DRB Application No.: 07DRB-70178 (P&F)

Project Name: JESUS ROMERO ADDITION, UNIT 2

17. **Project# 1005160**
07DRB-70178 MINOR - PRELIMINARY/
FINAL PLAT APPROVAL

SKETCH PLAT OF
 LOTS 2-A-1, 2-A-2, & LOTS 4-A-1, 4-A-2
 JESUS ROMERO ADDITION NO. 2
 PROJECTED SECTION 18, T. 10 N., R. 3 E., N.M.P.M.
 TOWN OF ALBUQUERQUE GRANT
 BERNALILLO COUNTY, NEW MEXICO
 JANUARY 2007
 SHEET 2 OF 2

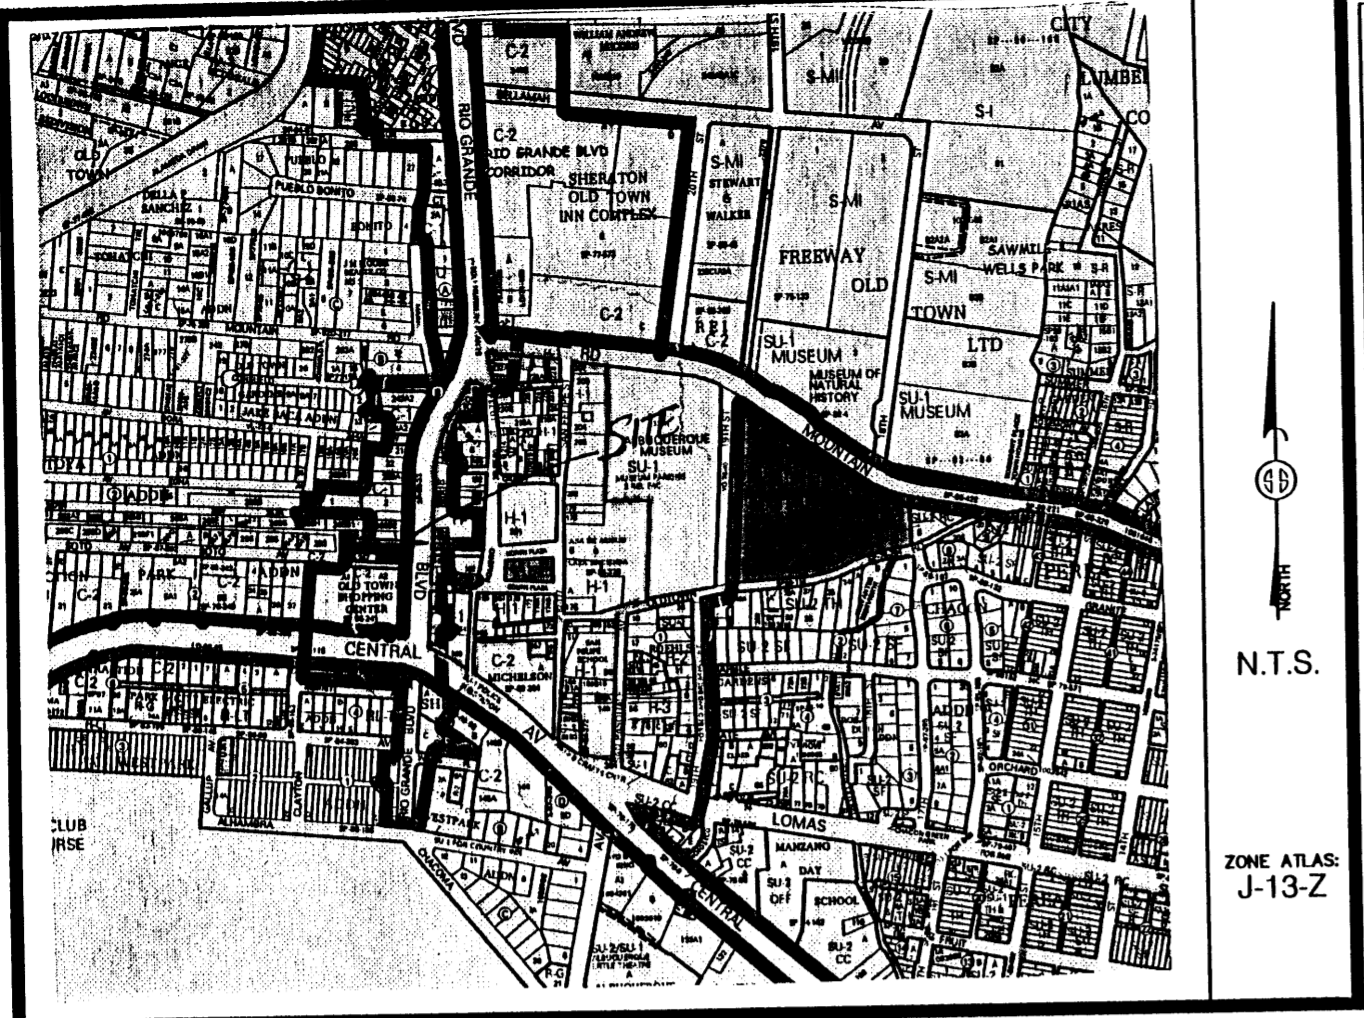
- 1) Does the alley provide access to lot 4-A-2? Is the alley paved?
- 2) A sidewalk dedication or easement along with infrastructure will be required along Hollywood.
